19 October 2021

**SSD-10450 – Dewatering Facility at 81 Gow Street, Padstow – Submission to State Significant Development – Canterbury Bankstown Council**

Council thanks you for the opportunity to provide comment in response to the State Significant Development (SSD) Application SSD-10450 for the proposed addition of a dewatering facility to the existing construction and demolition waste recycling facility at 81 Gow Street, Padstow.

Figure 10: Weekday AM Peak Hour Traffic Volumes with proposed traffic

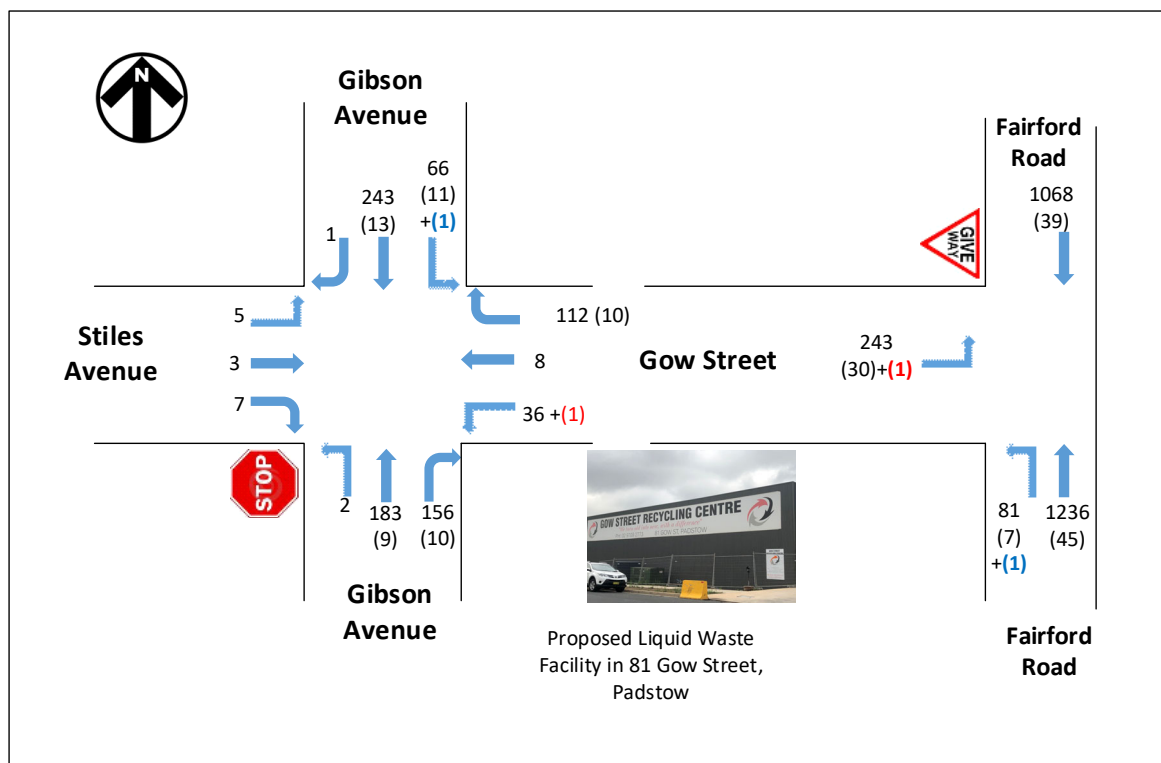
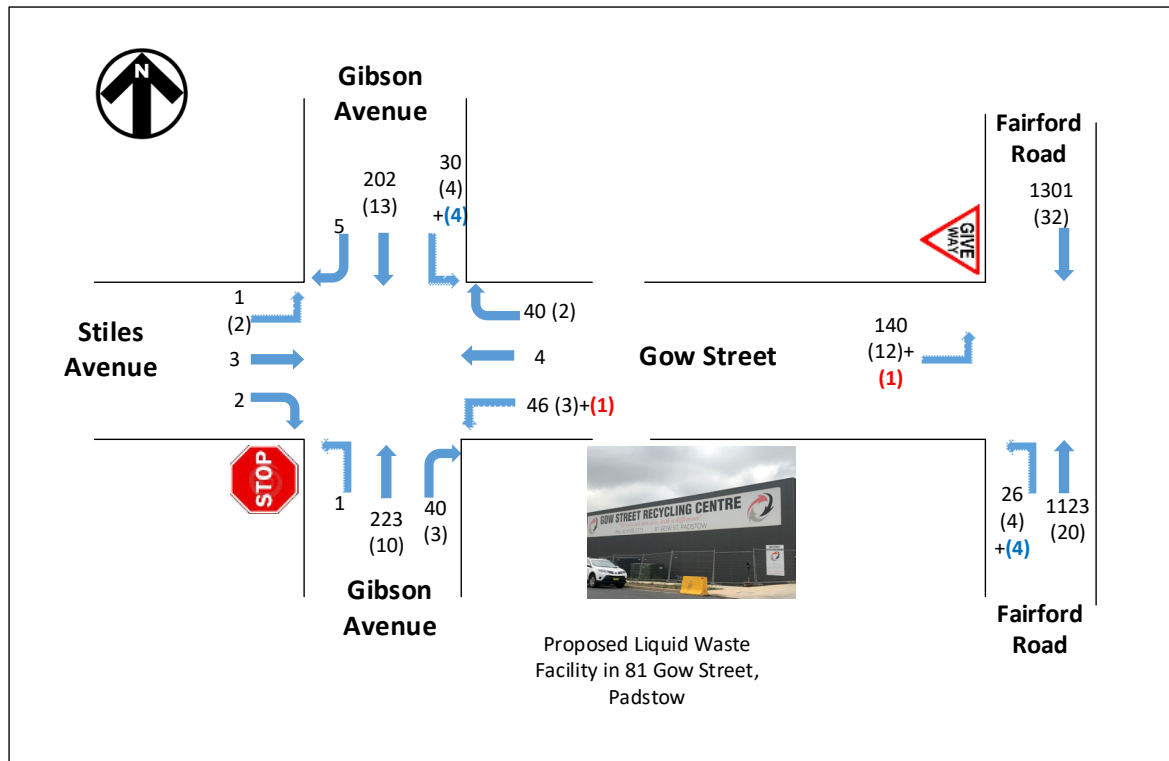
19. However, in the context of the current traffic arrangement (no left turn out of Gow St onto Fairford Road) the TIA has not adequately demonstrated the expected primary and secondary routes for heavy vehicles to and from the site. This is necessary for the assessment of the traffic impacts of the proposal and whether additional heavy vehicle traffic may impact nearby residential properties. Council notes that in their response to the SEARS TfNSW requested that the TIA include a description of haul route origins and destinations.

20. TfNSW also requested that the TIA provide an inbound/outbound vehicle profiles by time of day and day of week. The TIA submitted has modelled the AM/PM peaks but has also noted that liquid waste peak hour is not expected to occur during commuter peak hour with the majority of liquid waste pickups anticipated to occur from 7am onwards. Further information on the expected freight volumes to and from the site is needed to ascertain the potential impacts of heavy vehicle movements, particularly as

the application seeks to extend operating hours beyond those permitted under the current consent.

- f. The TIA be amended to include a description of haul routes for heavy vehicle traffic with potential origins and destinations, and whether residential areas may be impacted by these movements.
- g. The TIA be amended to include a profile of inbound and outbound vehicle movement by time of day and day of week.
- h. A swept path assessment showing a service vehicle entering and leaving the eastern driveway in a forward direction should be referred to the Traffic Unit for review.
- i. On-site parking rates should be calculated in accordance with the Bankstown DCP based on the existing C&D operations and the proposed dewatering facility. Any deviation from these rates should be appropriately justified on environmental planning grounds.
- j. The architectural plans should be amended to indicate the dimensions of the car parking spaces to demonstrate compliance with AS2890.1:2004.

Figure 3-4: Truck queuing

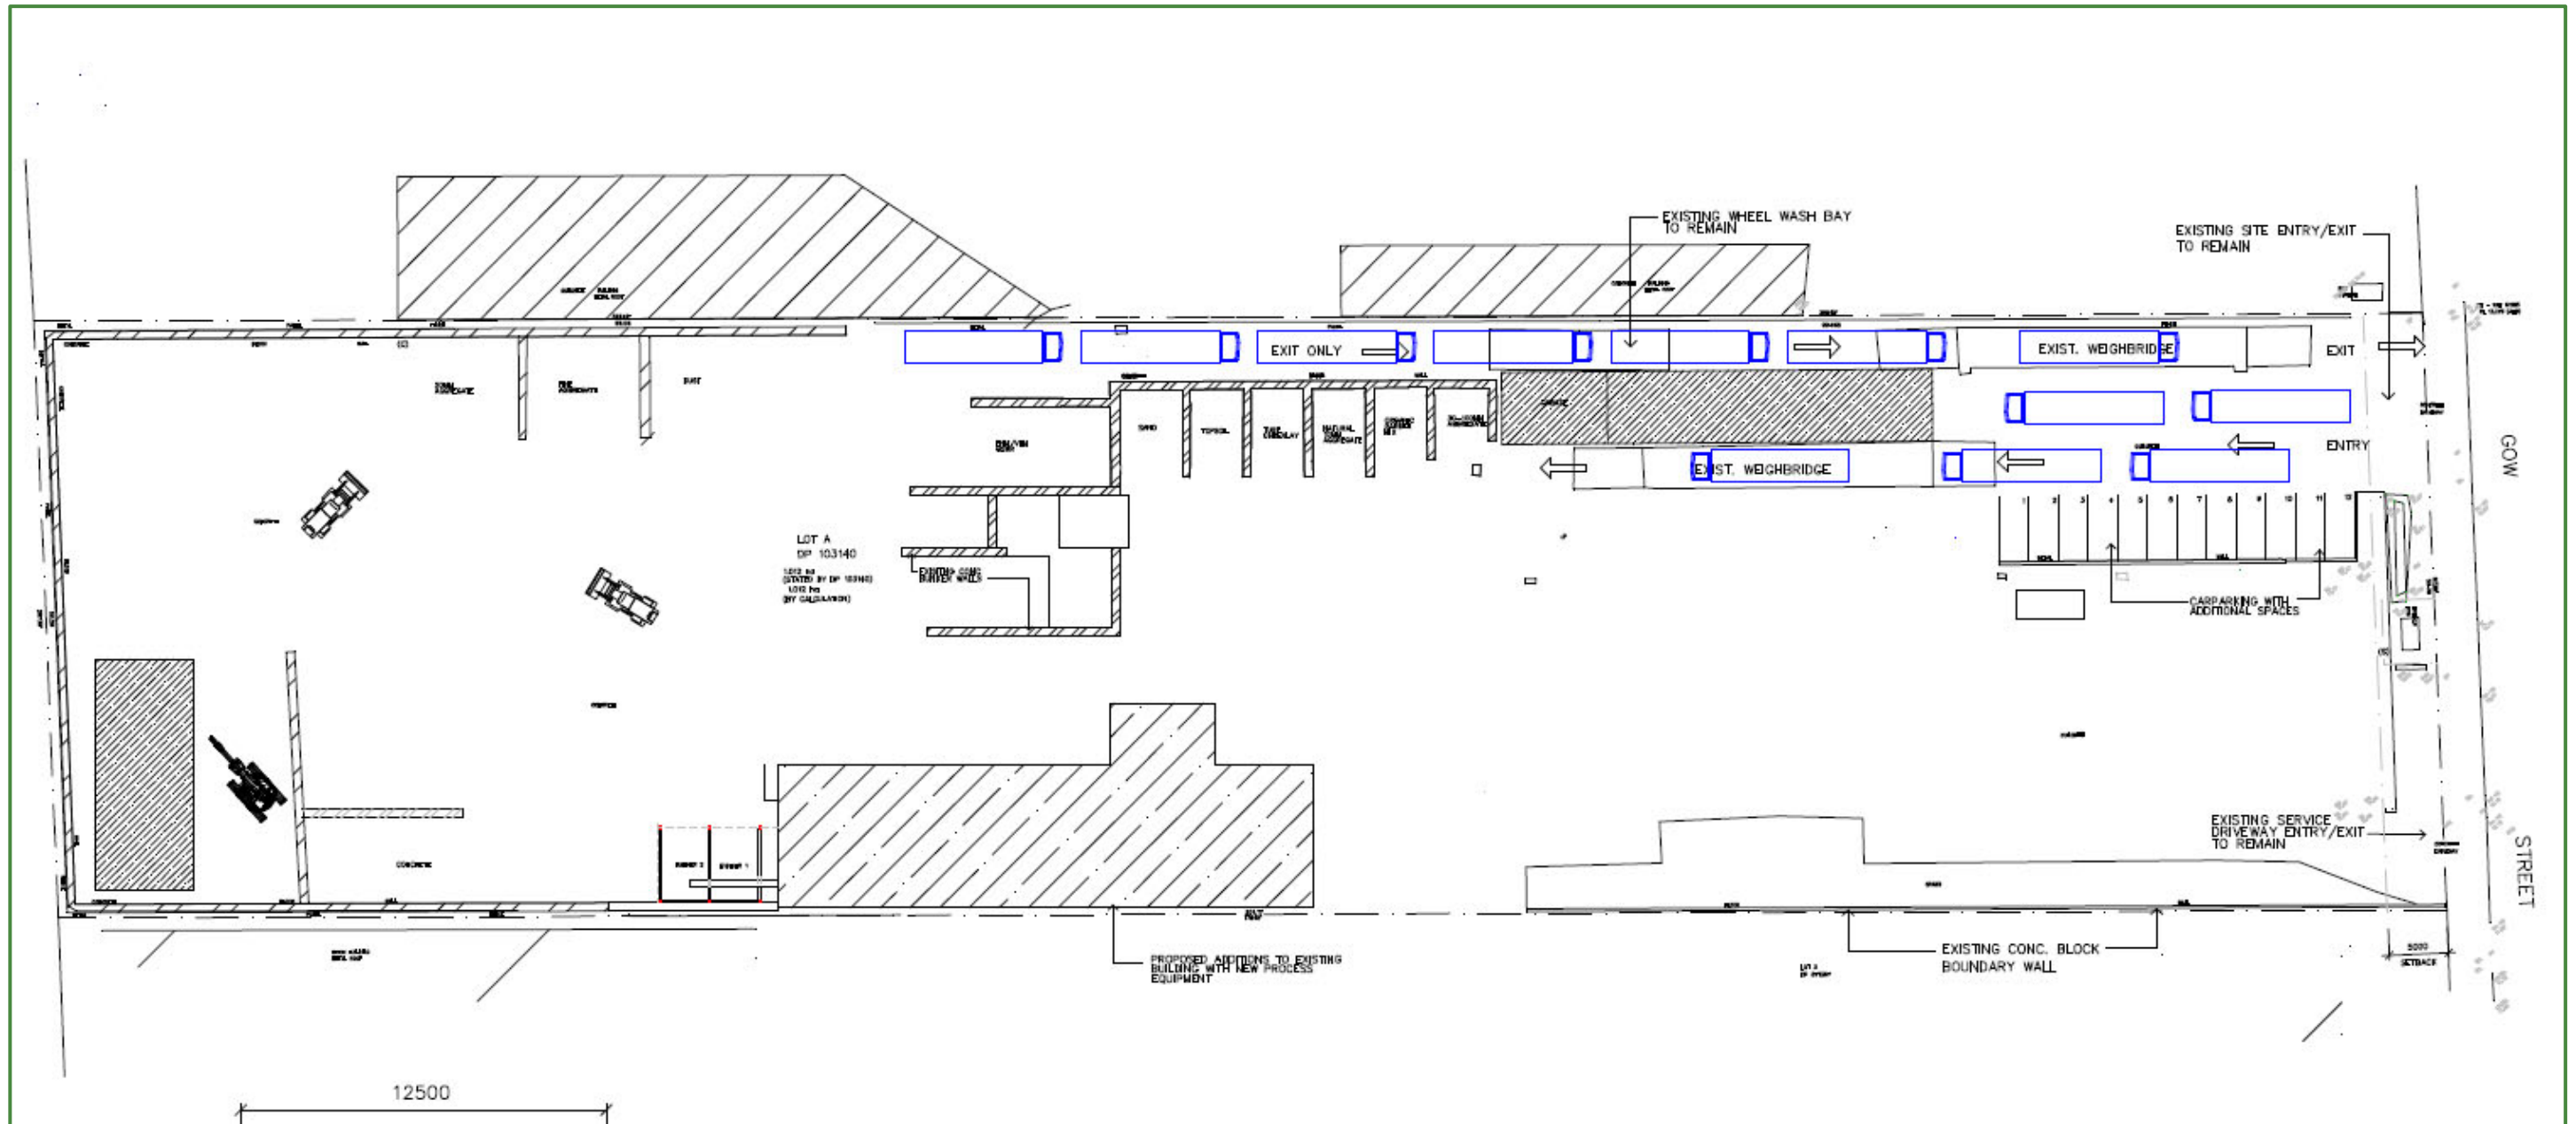
12. Internal truck circulation and onsite queuing arrangements have been submitted as part of the Traffic Impact Assessment (TIA).
13. Council notes that the secondary access point proposed is for the entry/egress of service vehicles and will not be used by trucks or heavy vehicles. However, it is not clear that the secondary driveway will allow a service vehicle to enter and leave in a forward direction.
